WEST SUSSEX COUNTY COUNCIL CONSULTATION

TO:	Arun District Council FAO: Mr S Davis
FROM:	Highways, WSCC
DATE:	18/07/2018
LOCATION:	Land west of Fontwell Avenue, 1 Fontwell Avenue, Eastergate PO20 3RU
SUBJECT:	AL/136/17/PL Erection of pair of semi-detached houses & new access onto A29 - This is a Departure from the Development Plan
DATE OF SITE VISIT:	n/a
RECOMMENDATION:	☒ Advice ☐ Objection ☐ Modification ☐ No Objection ☐ More Information ☐ Refusal
S106 CONTRIBUTION TOTAL:	n/a

PROPOSED SITE PLAN 1:500

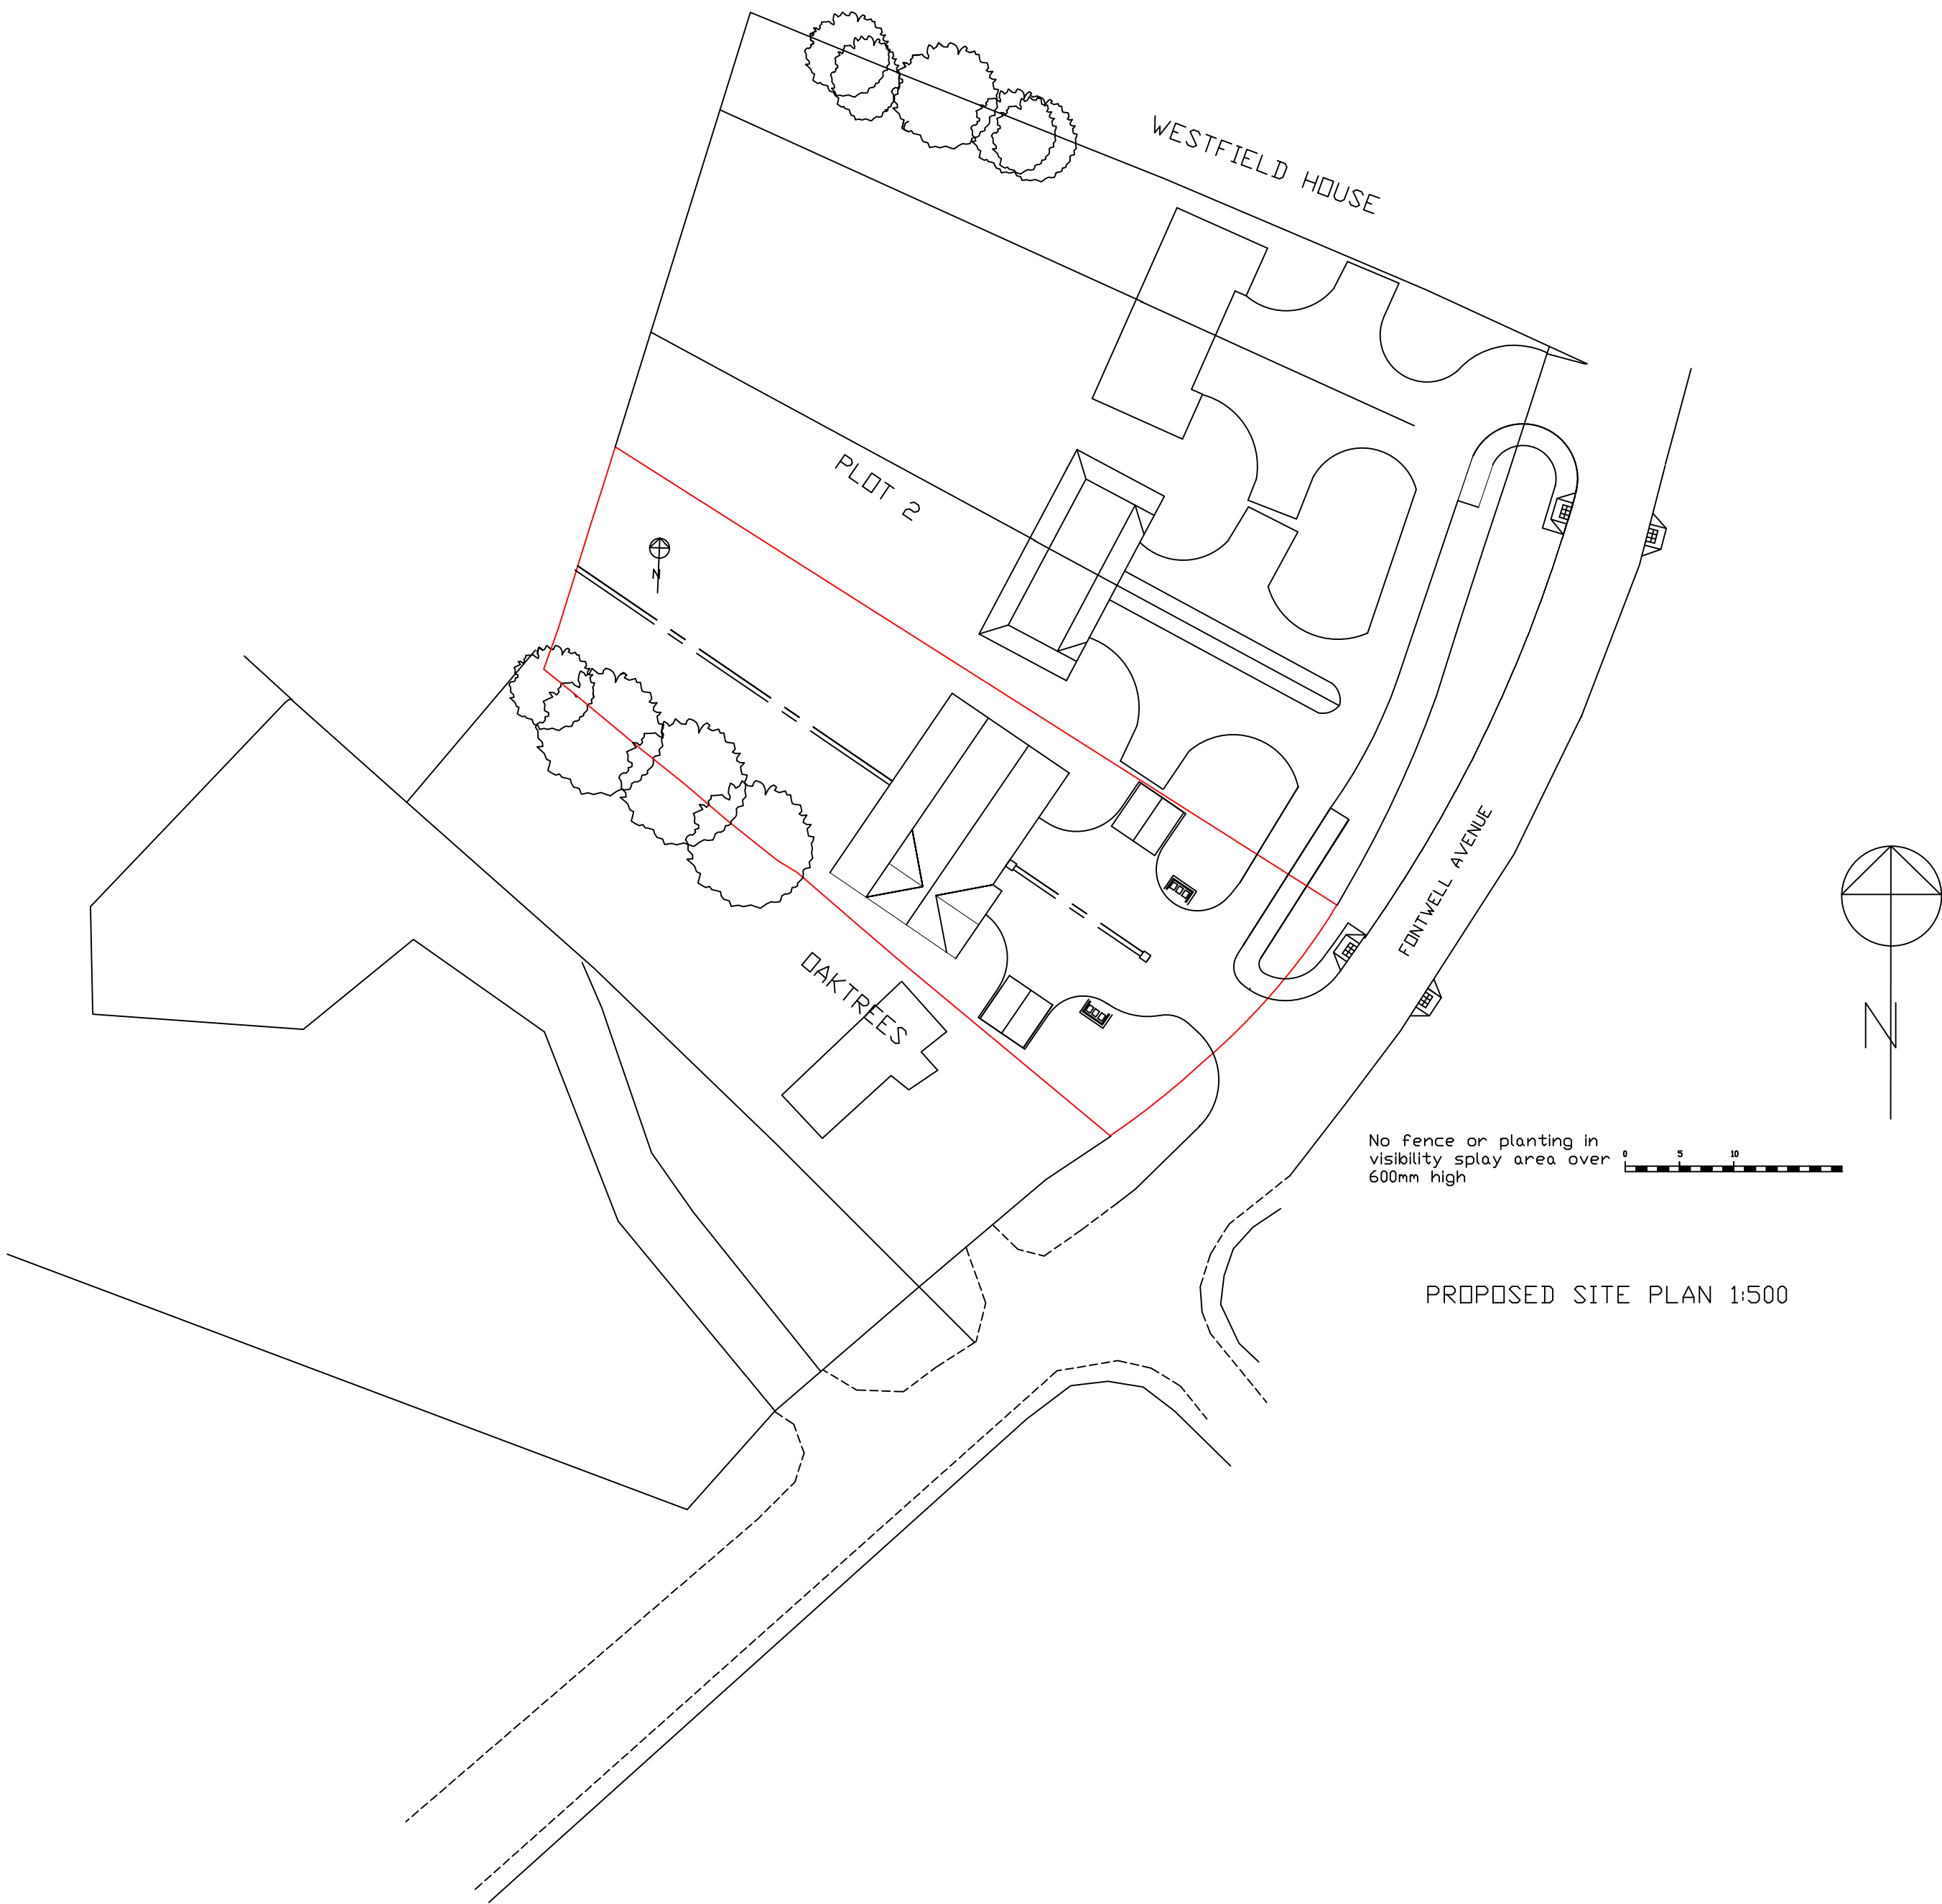
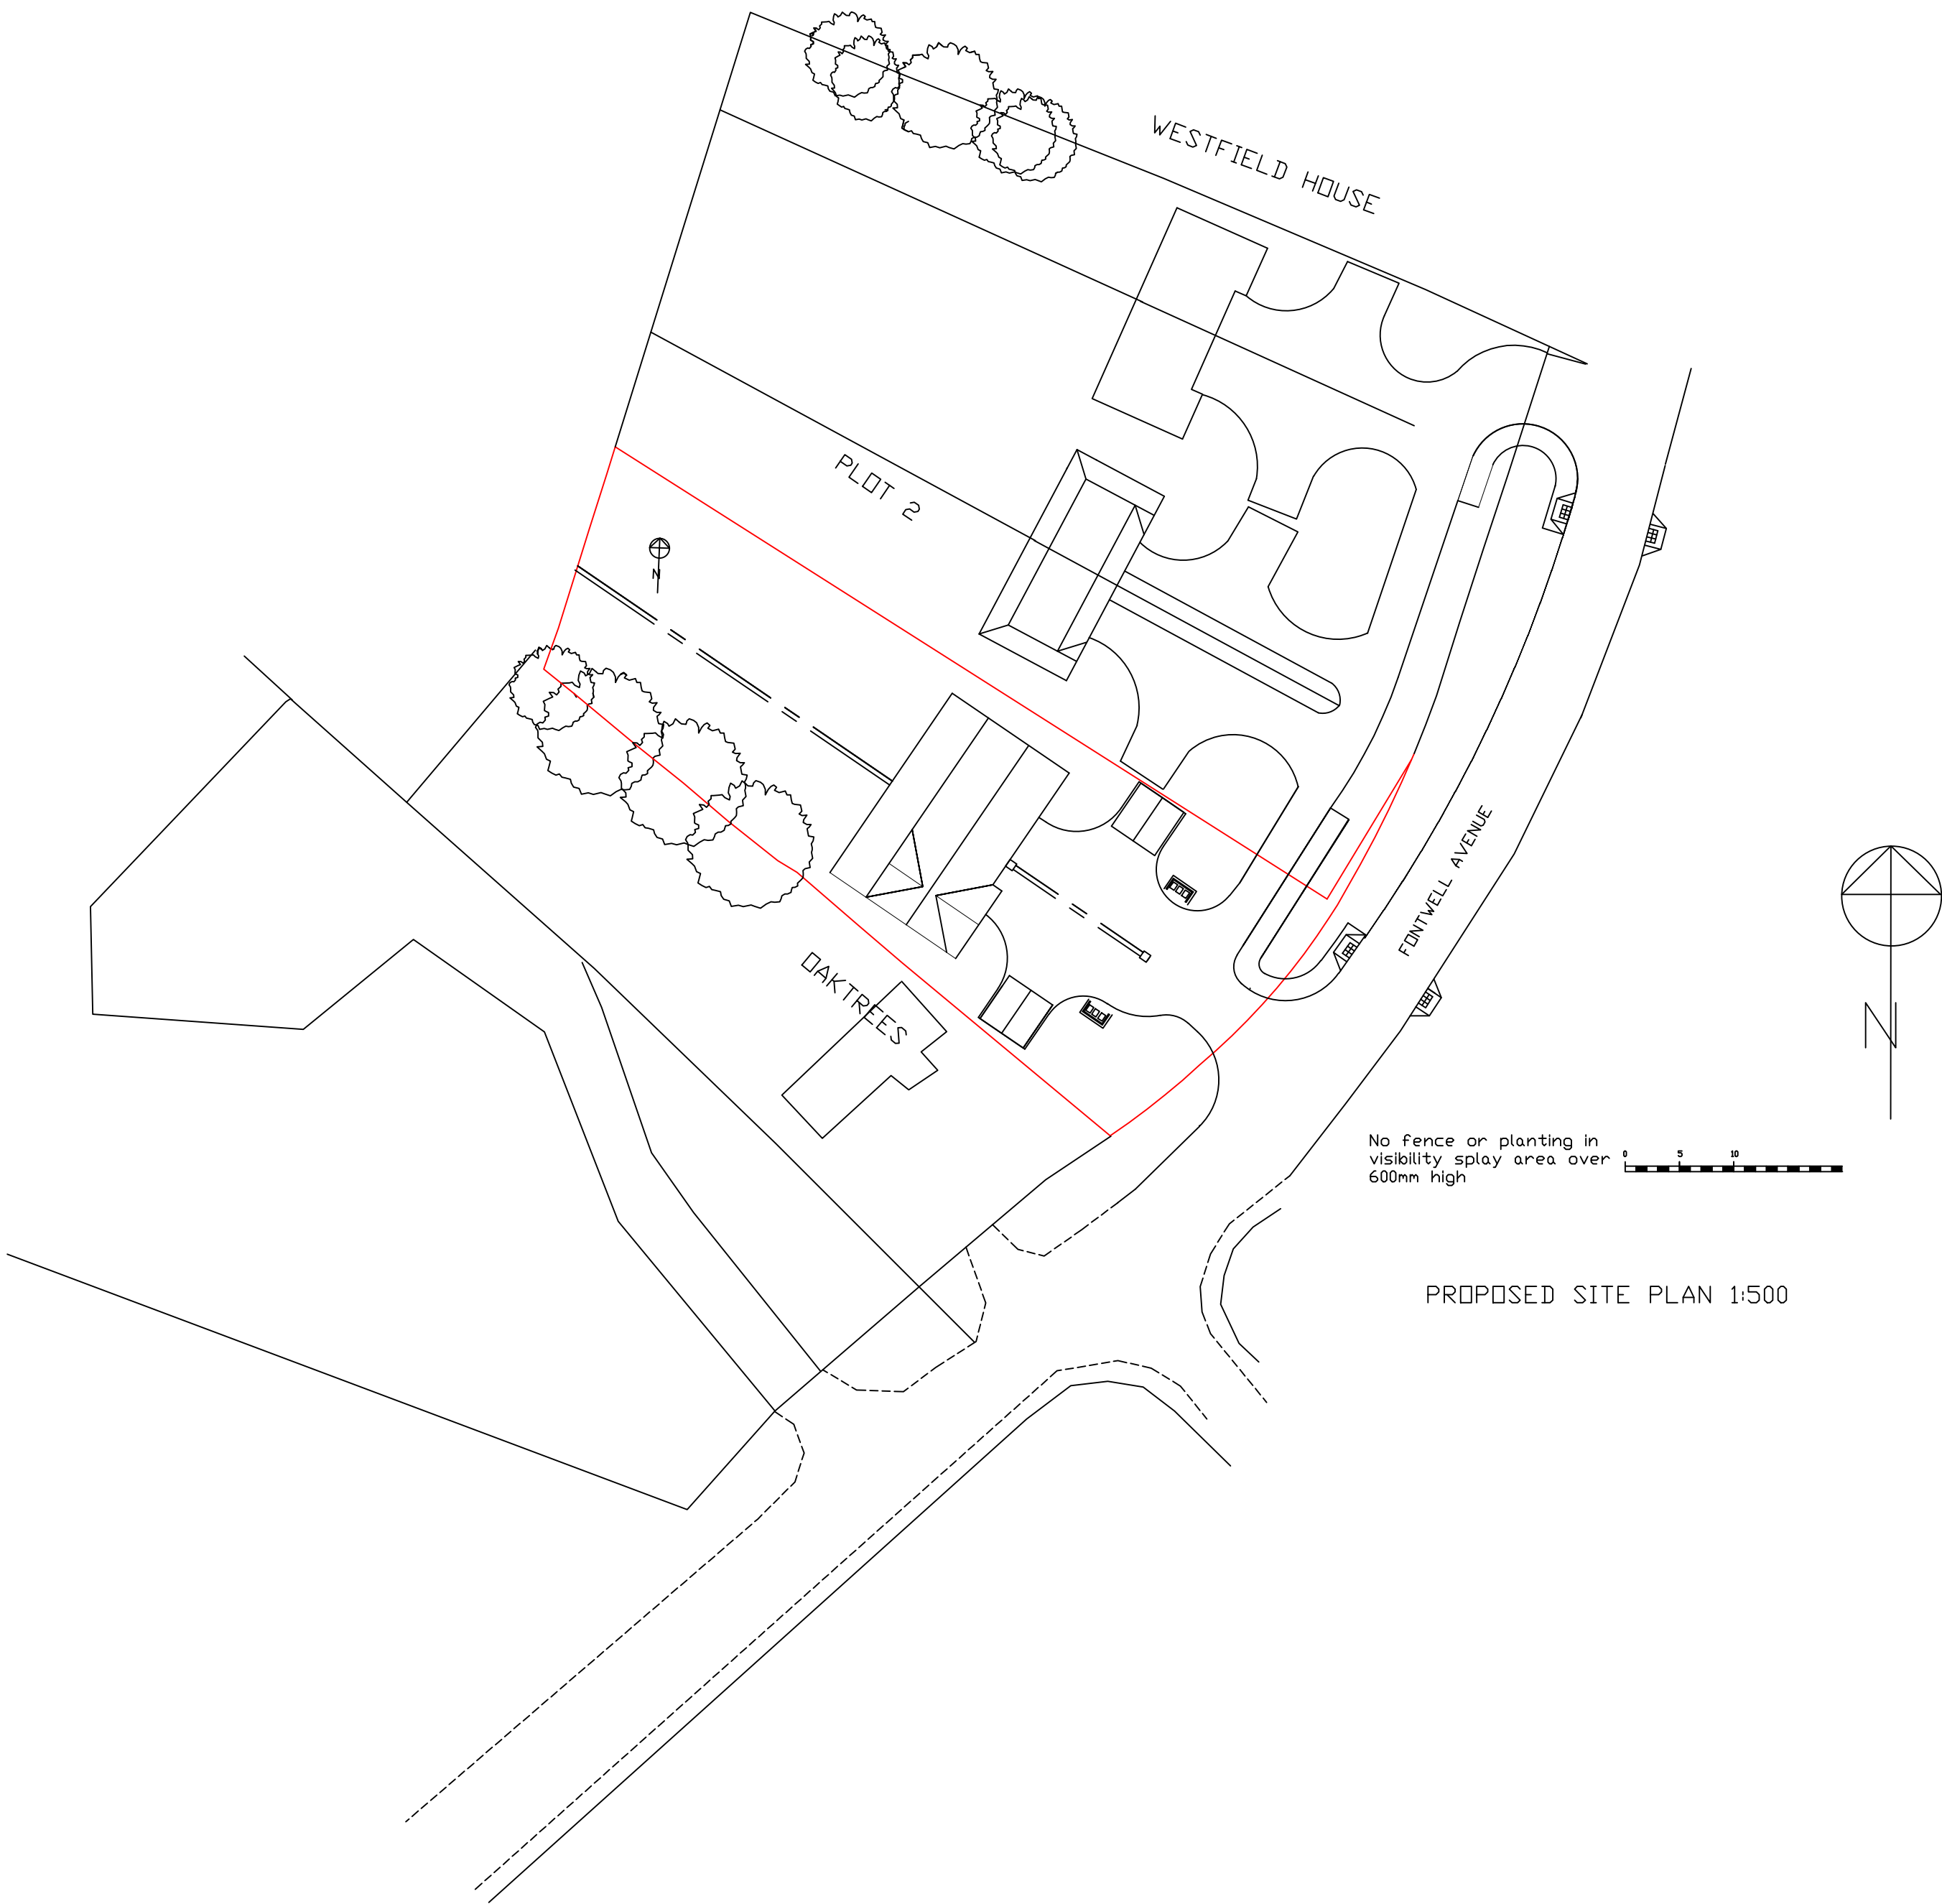
Using the latest submitted plan it is however possible to plot a 2.4 x 59 metre splay, however there would be a requirement to use land outside the red edge to provide such a splay. This land is etched in blue on plan 2018-4370-001 and therefore it is not unreasonable that the applicant could secure this land to provide adequate visibility splays by way of planning condition. The Local Planning Authority is advised that this would require an amendment the red edge plans submitted.

The additional plans address the concerns raised, we would just seek that visibility is secured in accorded with the previously recorded road speeds, this would require a slight amendment to the red edge plan to incorporate the splay, this seems achievable as this land is included within the blue edge. Please see comments for specific details.
